From: Anita Gardner <Anita.Gardner@arun.gov.uk>
Sent: 13 October 2020 09:57
To: Planning.Responses <Planning.Responses@arun.gov.uk>
Subject: FW: F/21/20/DOC Wicks Farm

From: Paul Cann <Paul.Cann@arun.gov.uk>
Sent: 13 October 2020 09:55
To: Stuart Magowan [REDACTED] Anita Gardner <Anita.Gardner@arun.gov.uk>
[REDACTED]
Subject: RE: F/21/20/DOC Wicks Farm

Reservoir Catchment:

MANHOLE SW-06
WITH HYDROBRAKE
(Scale 1:25)

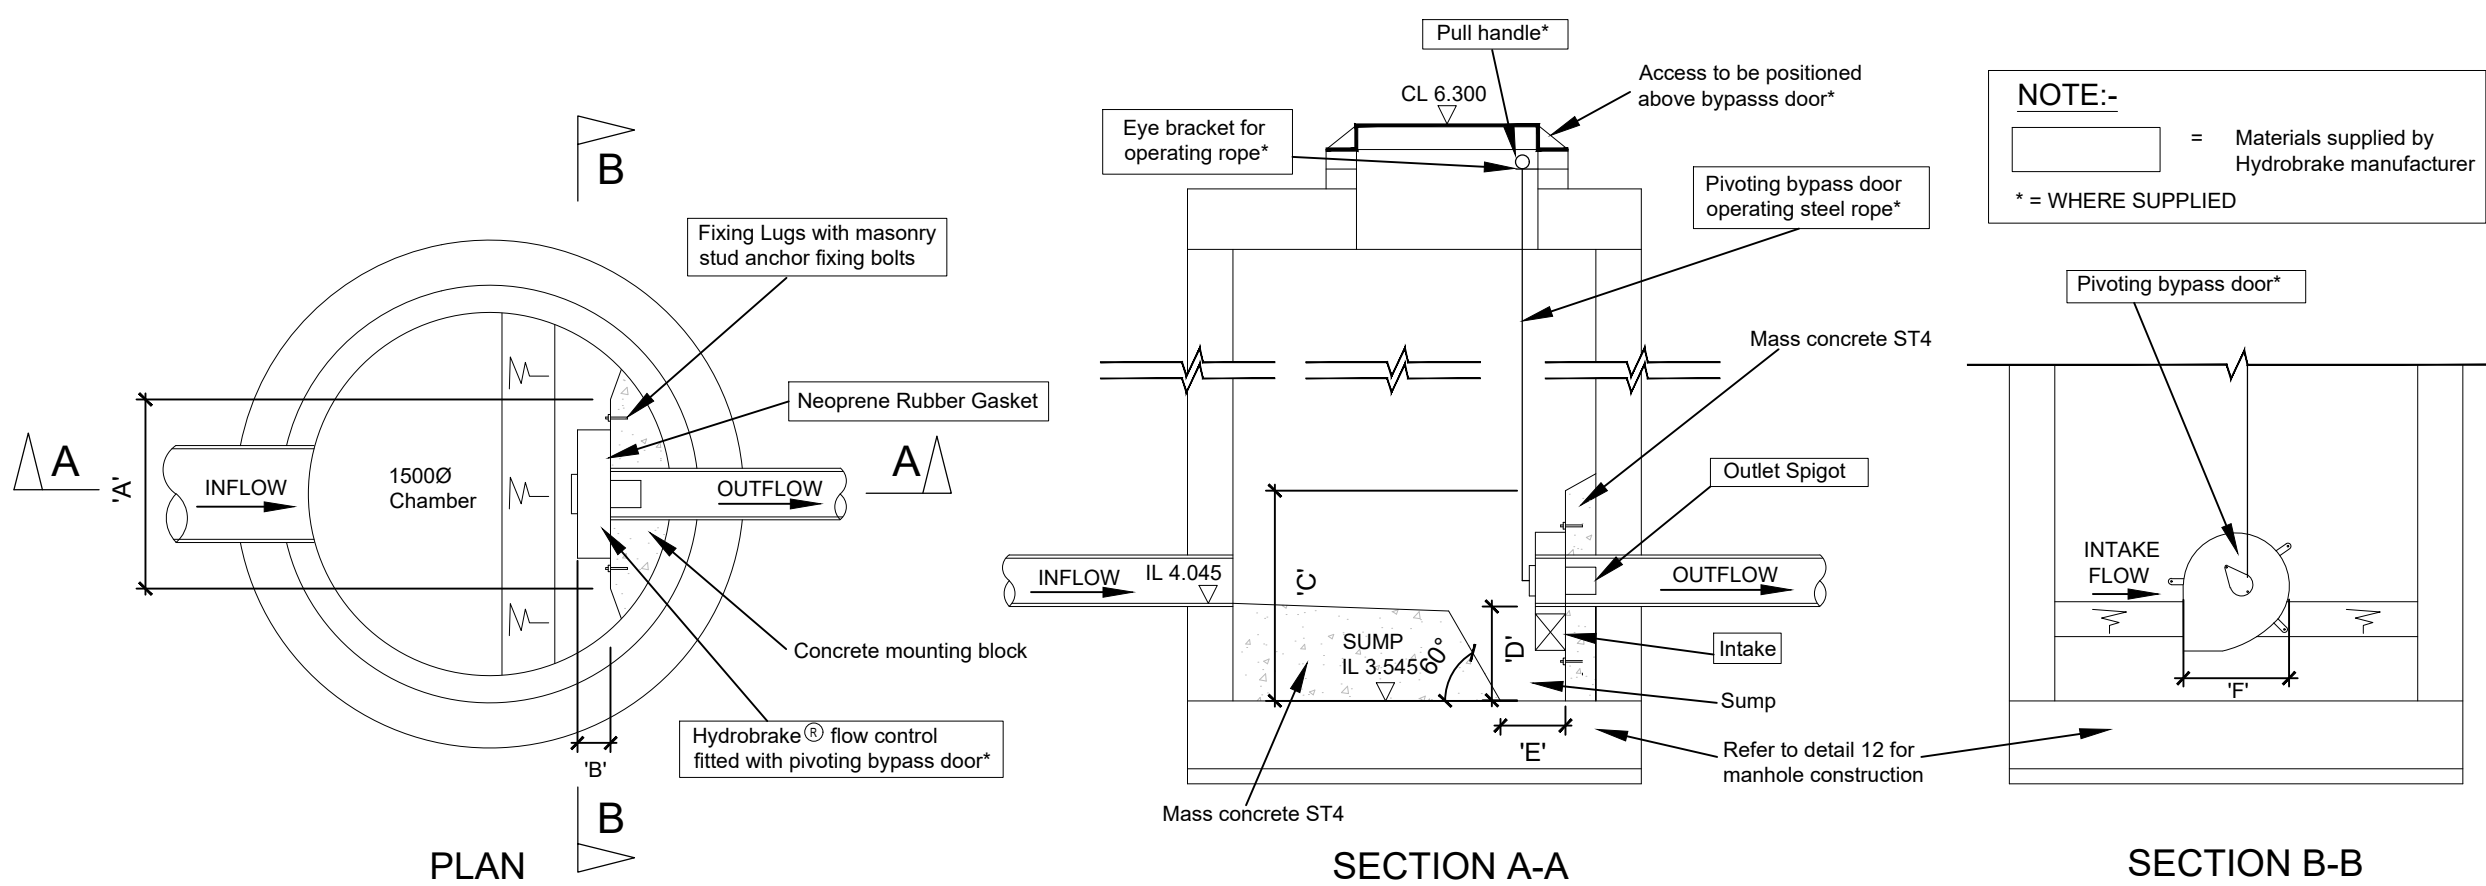
6. **Specify gradient between overflow pipe and hydrobrake chamber.** The gradient is 1 in 44 and is included on drawing 22E. ok. Noted.
7. **Provide hydrobrake chamber construction detail.** Noted and included in the link above on drawing 52B. Cover level and invert level are relevant to SW-07 – I would suggest just adding a note – ie. refer to the relevant layout drawing. Whilst the chamber construction details make reference to the details shown on 'manhole construction no.12 drawing', please specifically mention a granolithic finish to the benching. The Hydrobrake detail has been amended to say refer to layout Drawings 22 and 24 for Cover Levels, Invert Levels and Sump Levels. The note regarding the manhole construction and granolithic benching finish updated on detail also. See Drawing 52C.

17. Provide hydrobrake chamber construction detail. Noted, included in the link above on drawing 52B. See item 7 above – similar comment applies. Noted. See my response to item 7 above.

ALTHON HEADWALL R10CA
(Scale 1:20)

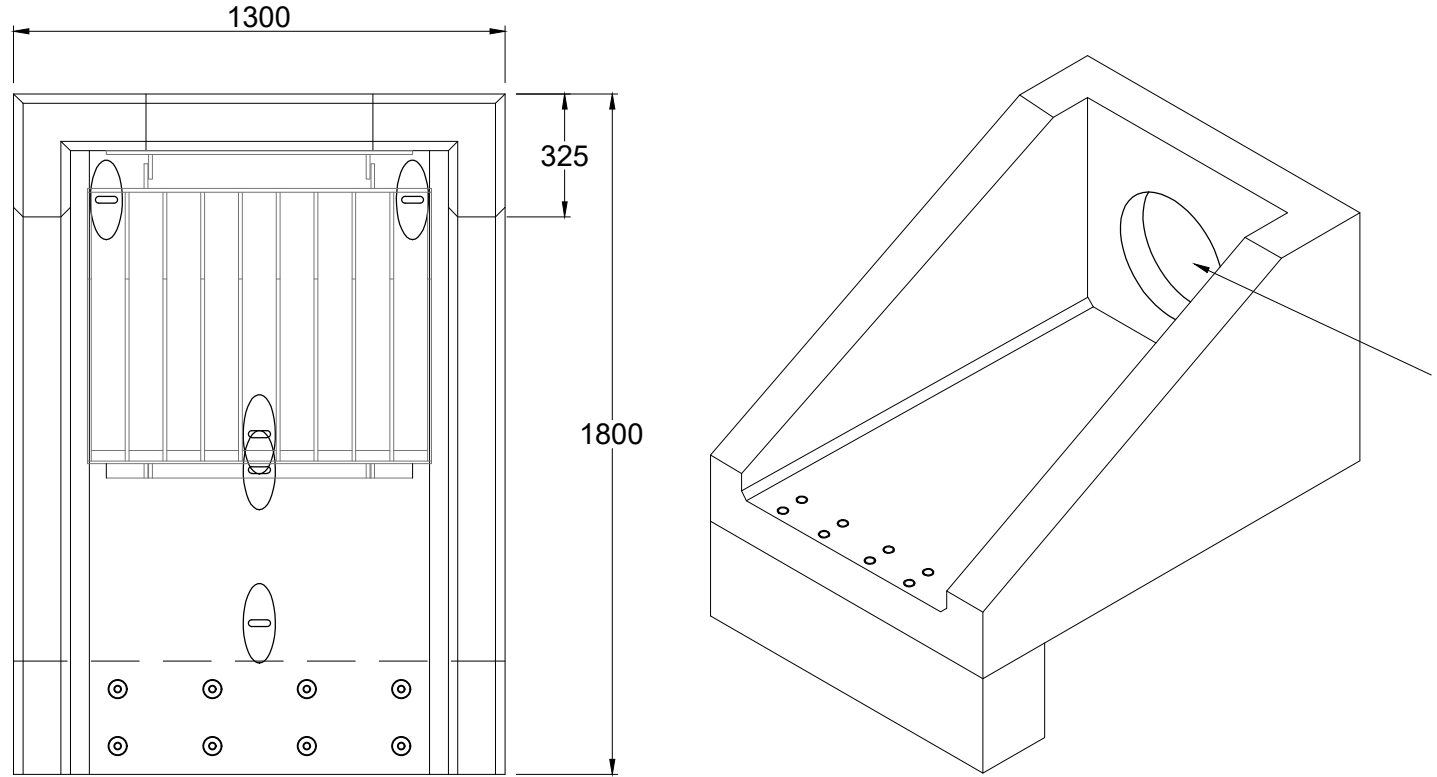
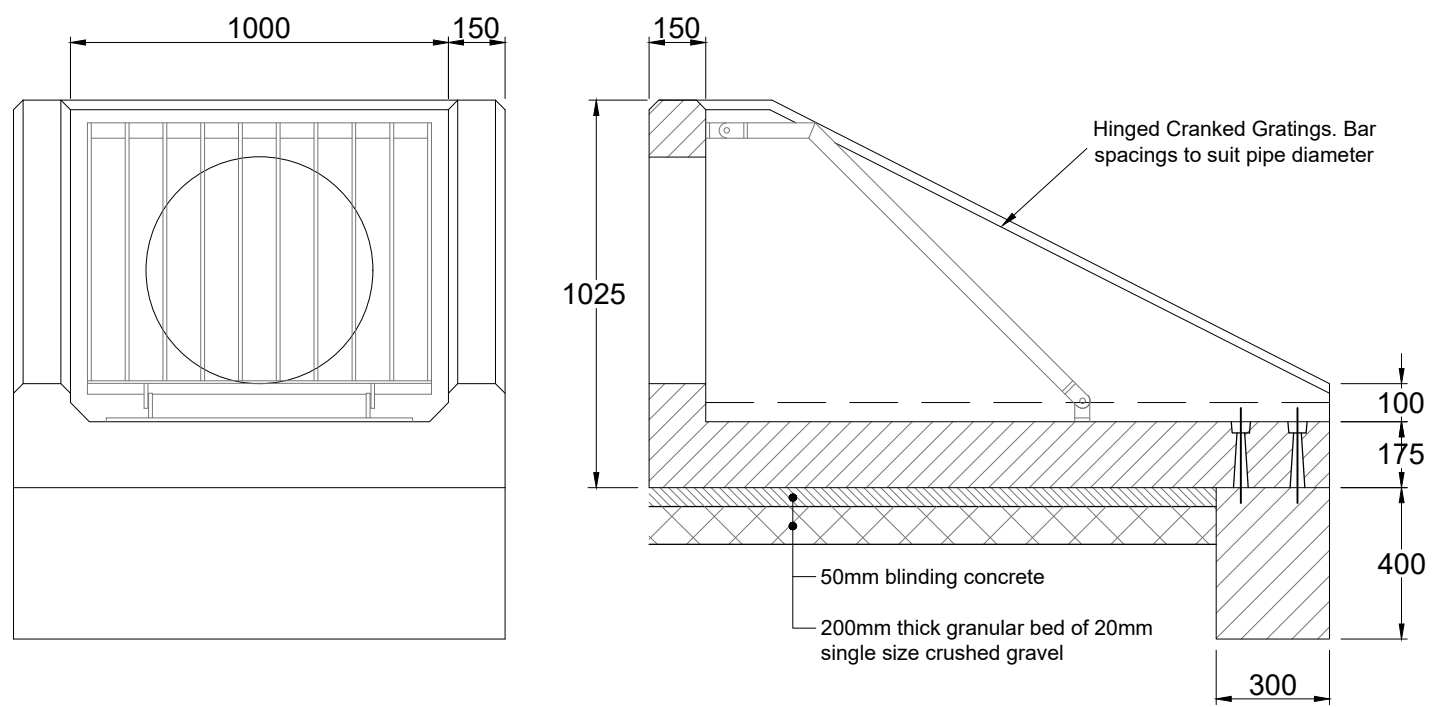
5. **Overflow pipe from reservoir provide headwall with cranked grille with bar spacings to suit 150mm diameter pipe. Include construction detail.** Detail of Althon Headwall R10CA with cranked grill and installation instructions provided on 13 July 2020 and are included in the link above on drawing 53. Ok. Noted.

CLIENT DPS Limited	
PROJECT Wicks Farm Polytunnel Ford	
TITLE Sections	
DRAWN P Reynolds	DATE Aug 2020
ENGINEER S Burgess	CHECKED SB
SCALE As shown @ A1	
PROJECT NO. 23210	
REV

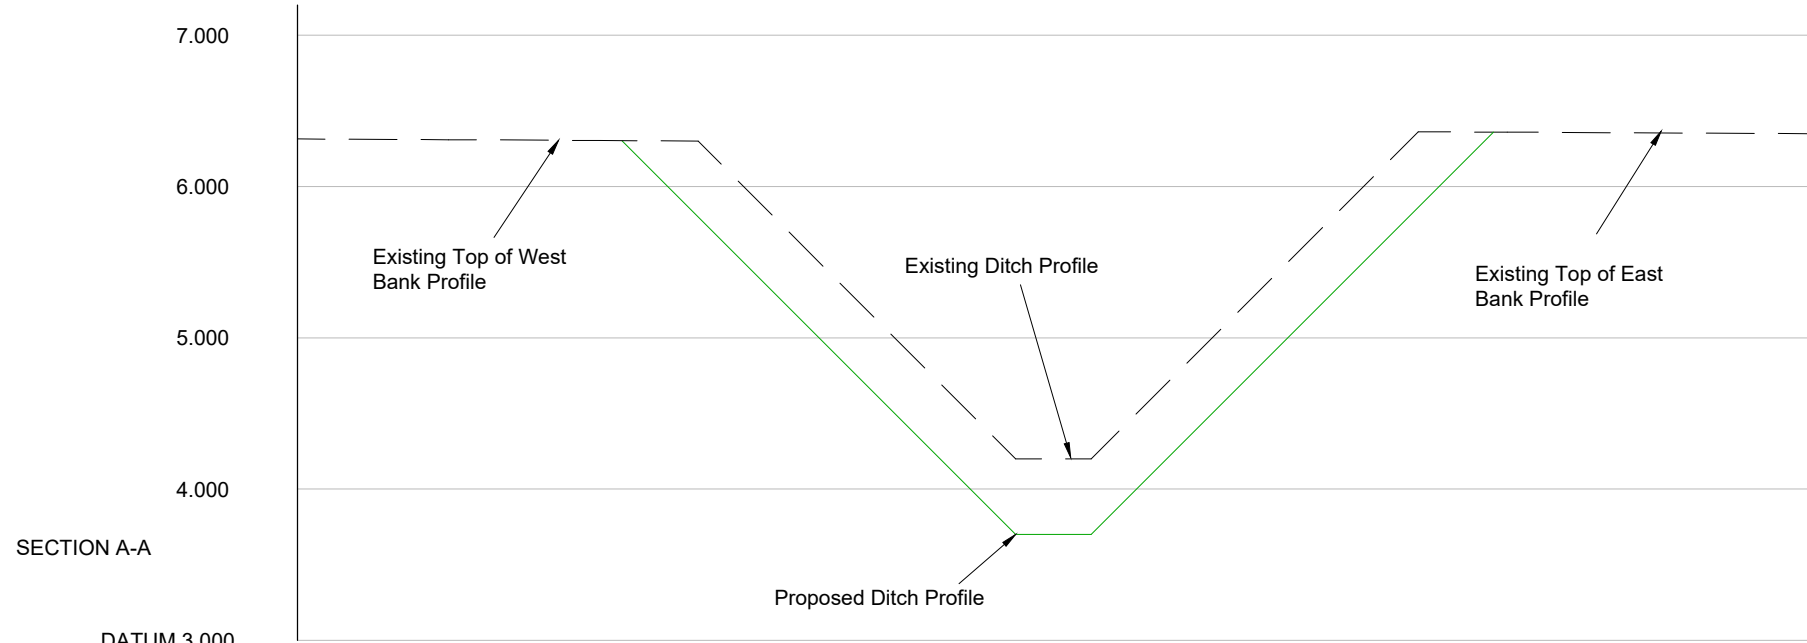
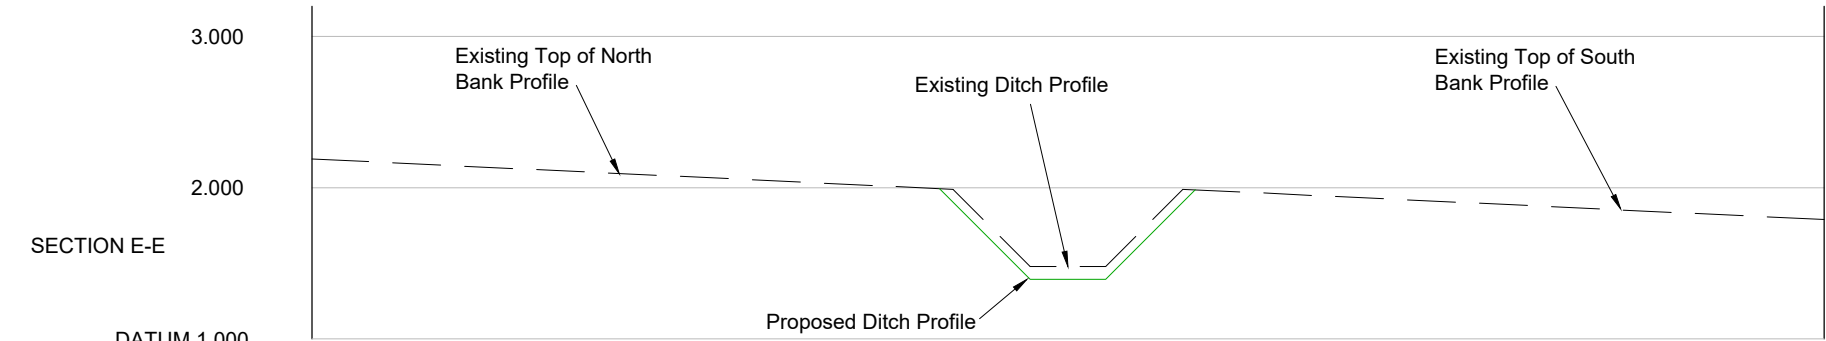
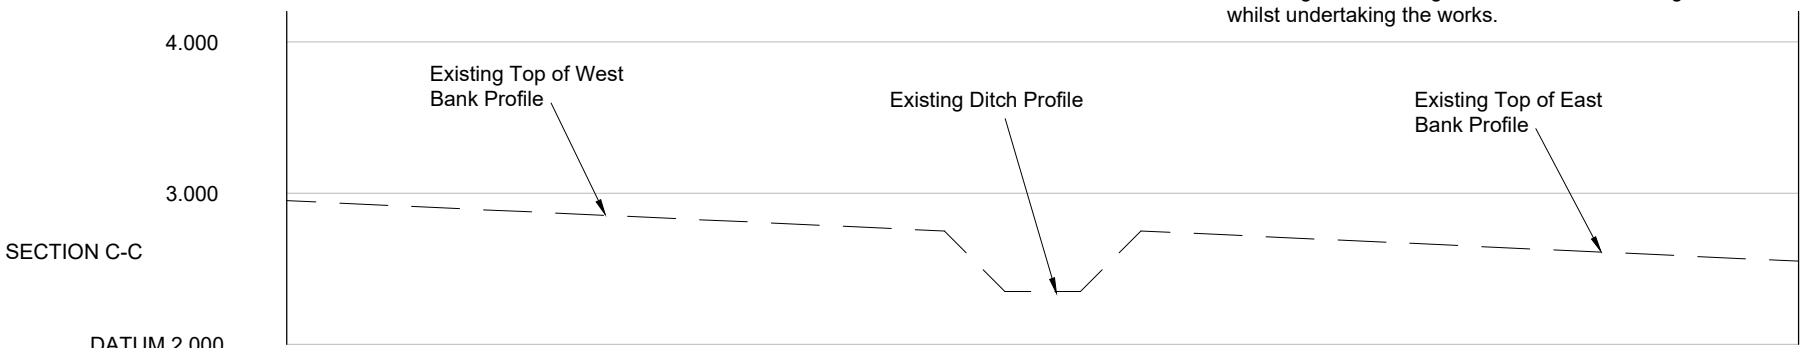
1. The northern boundary ditch in vicinity of the proposed reservoir is currently located on the other side of the network rail fence and not within the redline boundary. As previously suggested a ditch will be required within the red line boundary and running parallel to the network rail ditch. Please adjust drawings and provide a typical profile cross section. Land drainage consent is also required for the new ditch and headwall outlet. There is an existing ditch on site at the northern boundary and a further ditch the other side of the Network Rail fence, the existing ditch is noted to be cleared of debris, vegetation and silt and regraded where required. This is indicated on drawings 21E, 22E and 24E. The comments on Land Drainage Consent are noted but are not a reason to refuse discharge of condition as they are covered by separate legislation. My last visit to site indicated that there was no obvious ditch in vicinity of the reservoir, apart from the one on the other side of the Network Rail fence, however, provided the ditch is installed as per the drawings then this is not an issue. On the cross sections ie. D-D and E-E, clearly indicate the ditch base width and the gradient of the side slopes. Land drainage consent is an integral part of the outstanding conditions ie. no.8, and in this instance, I am prepared to allow the consent to be just made for the headwall structure/discharge -- please therefore submit as necessary. Noted. The ditch base and bank gradients have been added to all sections A-A to E-E. See Drawing 70. Ok

LONG SECTION - WESTERN DITCH
(Horizontal Scale 1:500 / Vertical Scale 1:125)

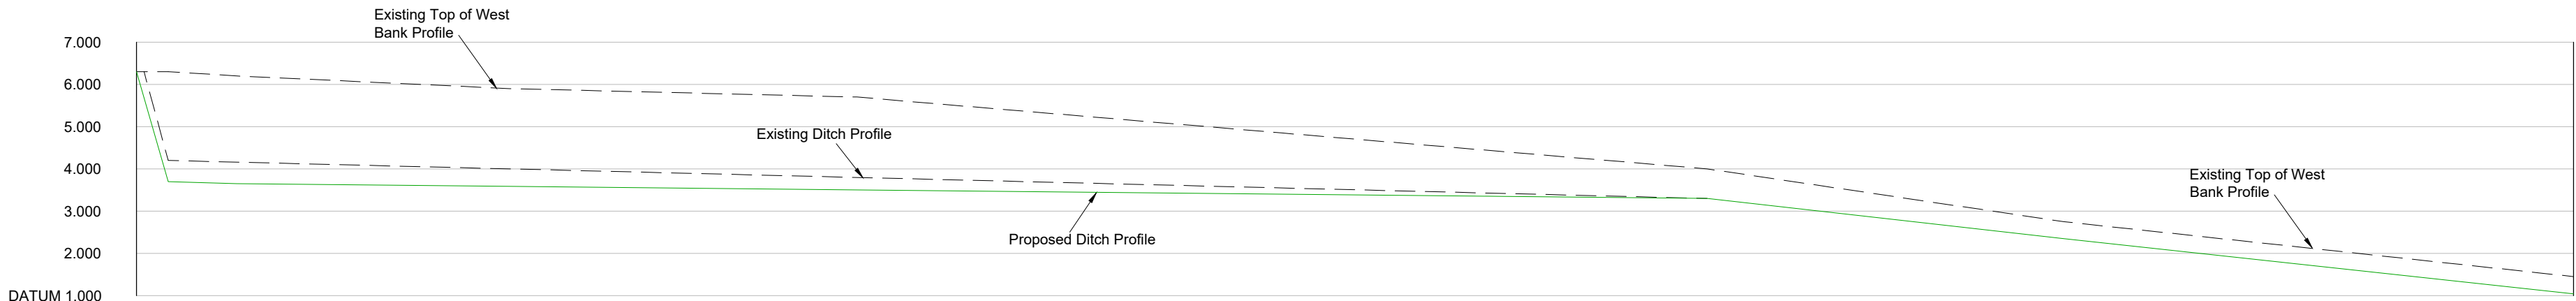
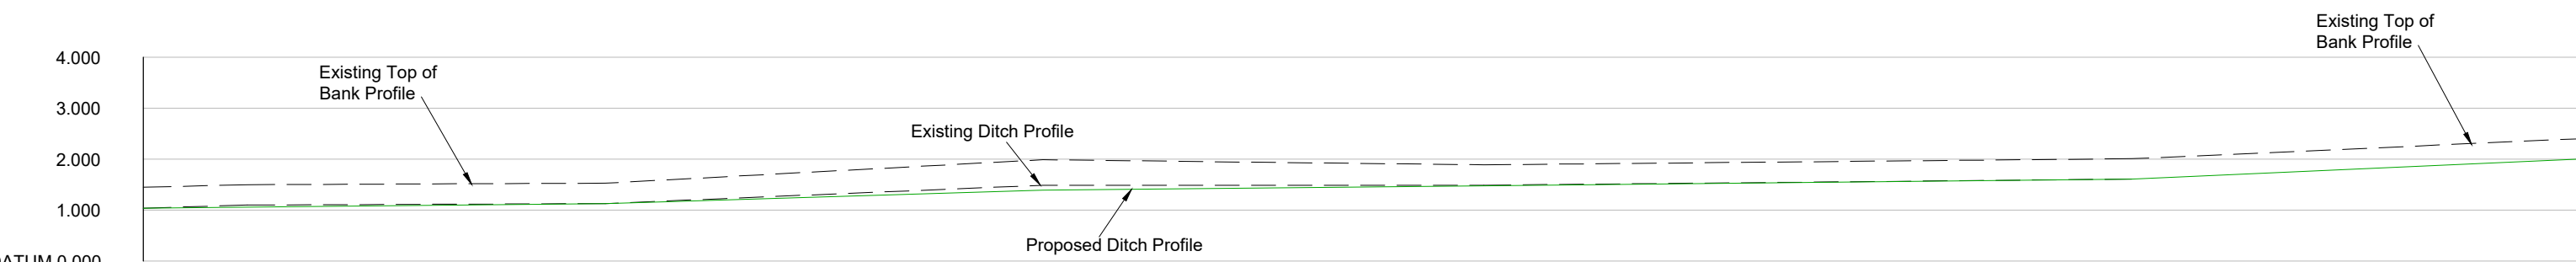
11. **Provide longitudinal section showing existing and proposed bed levels.** This is an existing ditch, we have provided the existing levels on the submitted drawings, long section is included in the above link on drawing 70. Ok. Noted.
